Uisce Éireanns Ref: PN26000040751

ACP Planning Ref: 323780

10 year planning permission for Ballinlee Wind Farm consisting of 17 no. wind turbines, a permanent 110kV substation and ancillary development located in Ballincurra, Ballingayrou, Ballinlee North & South, Ballinrea, Ballyreesode, Camas North & South, Carrigeen, Knockuregare, Ballybane and other townlands in County Limerick.

Figure 17-13: Existing Water Infrastructure

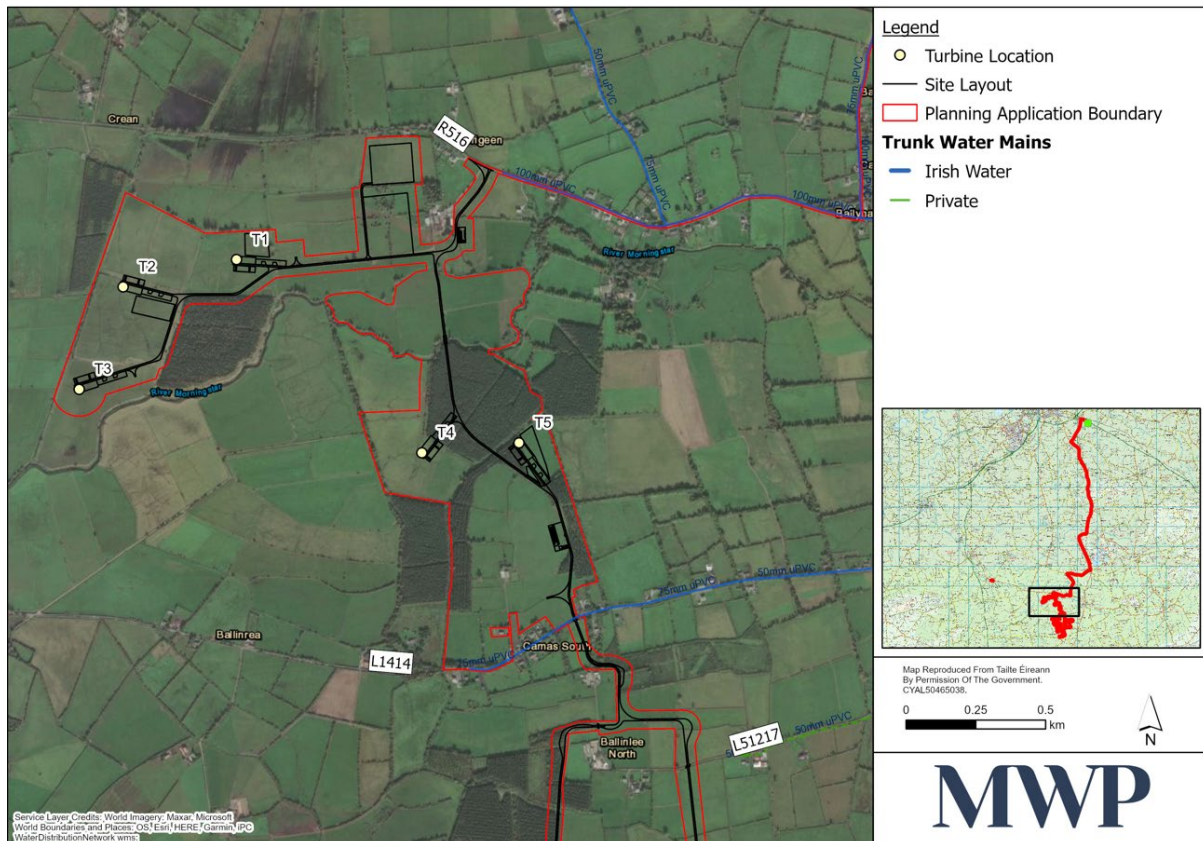
7. The Grid Connection Route crossing important and strategic Uisce Éireann infrastructure. The applicant / developer shall obtain a Confirmation of Feasibility from Uisce Éireann, through engagement with Diversions@water, for a schedule of crossings and safe separation distances from Uisce Éireann infrastructure along the route the proposed grid connection, prior to commencement of works for this element of the proposed development.
